**From:** [Mike Podobnik](#)  
**To:** [Jamey Ayling](#)  
**Cc:** [CDS User](#)  
**Subject:** Public Comments on Fowler Creek Guest Ranch, CU-23-00003  
**Date:** Thursday, October 19, 2023 12:09:37 AM  
**Attachments:** [Letter of opposition to Hidden Point Project Application CUP-20-20005.pdf](#)  
[Letter for the Residents of the Granite Creek Community dated 18 Oct 2023.pdf](#)  
[Fearful Mother- Request for Comment on Behalf of FD-7, John Sinclair, District 7 Fire Chief.pdf](#)

October 18, 2023

Re: Fowler Creek Guest Ranch, CU-23-00003

FOWLER CREEK GUEST RANCH
EXHIBIT 12
EMERGENCY INGRESS AND EGRESS PLAN

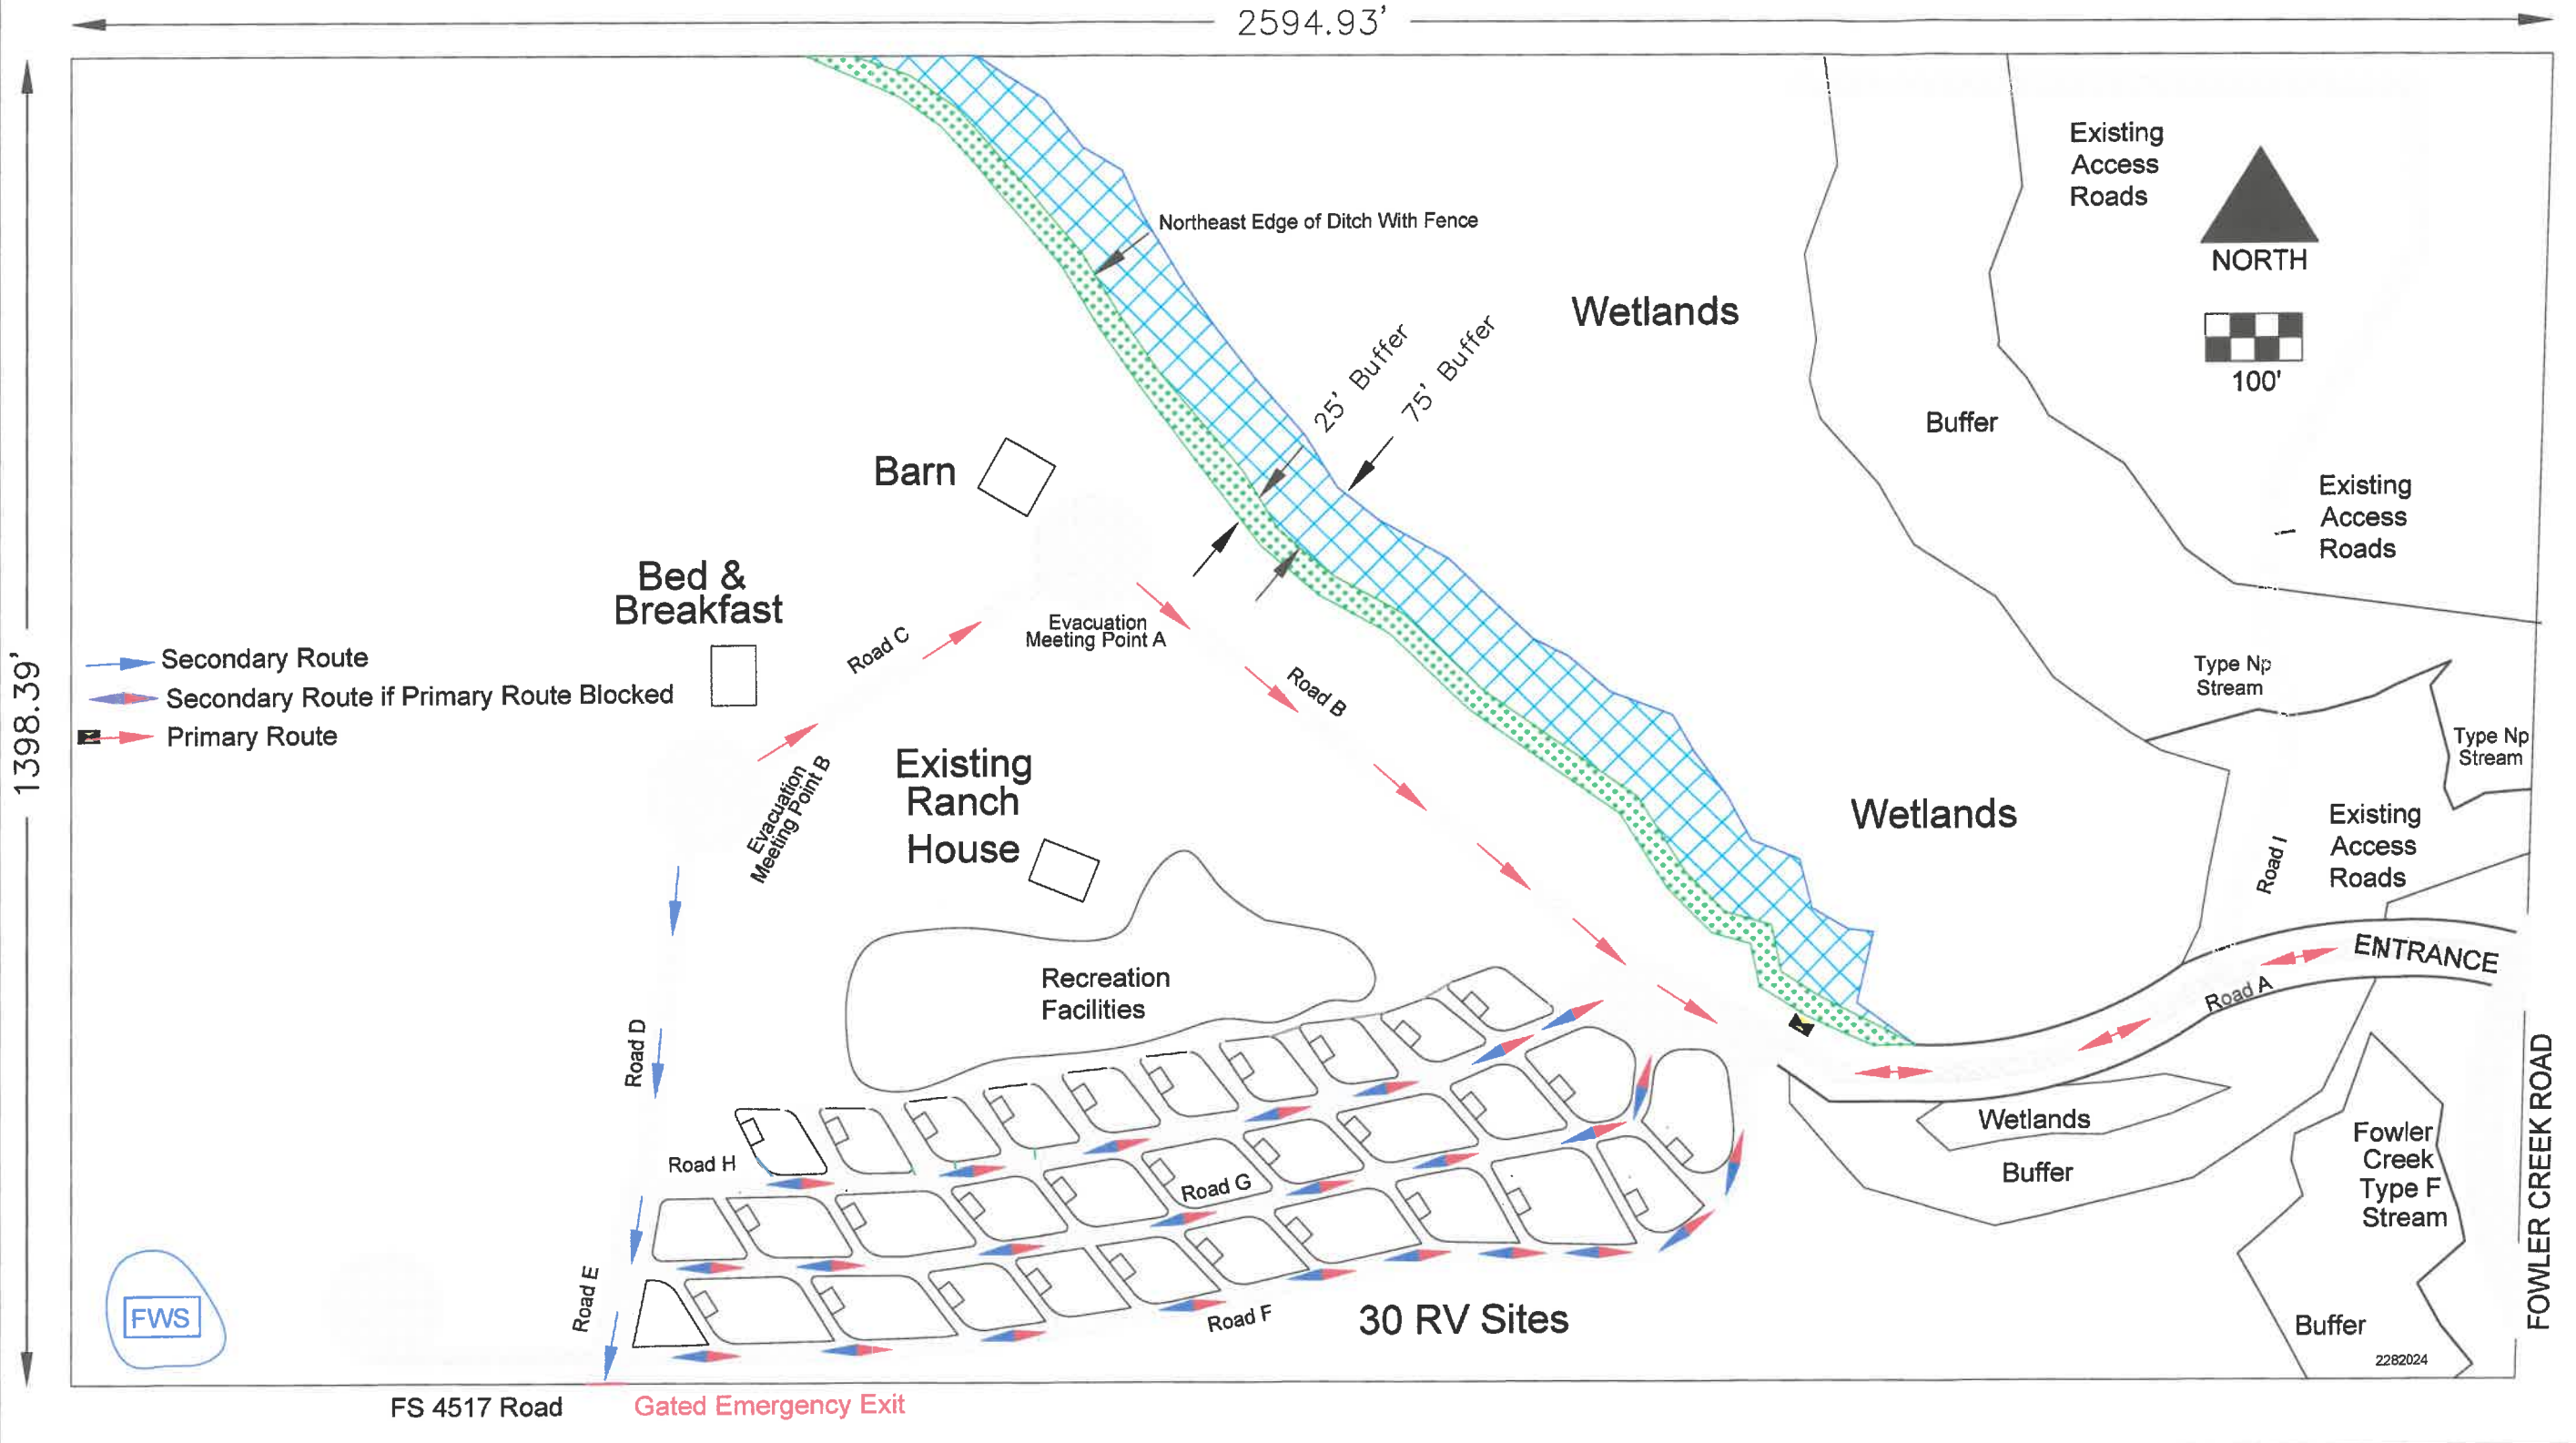
PE raises FS Rd 4517 serves as the single and only readily available egress for the Granite Creek neighborhood (Attachment 2). For our community, there is only one way out for our neighbors and one way in for emergency responders. However, as proposed, the two access points to the proposed development introduce egress points in close proximity and one of the two intersects with FS Rd 4517, labeled "Exit" on the [Site Plan](#). Under normal weather and/or non-emergency conditions the road is questionable, but clear questions have been raised about whether FS Rd 4517 can capably meet current standards for line of sight, stopping distance, turning radii, particularly for RVs and trailers, zone requirements, and roadway width. This risk escalates greatly in inclement weather, such as winter snow, and in the event of emergency, such as a wildland fire. In reality, no engineering analysis nor appropriate traffic impact analysis has been completed to ensure safety, compounding risk for hundreds of residents, short-term guests, event attendees, and emergency responders alike. John Sinclair, District 7 Fire Chief, put the implications plainly, stating "Bottom line, we run the risk of future loss of life in a rapidly moving wildland fire."
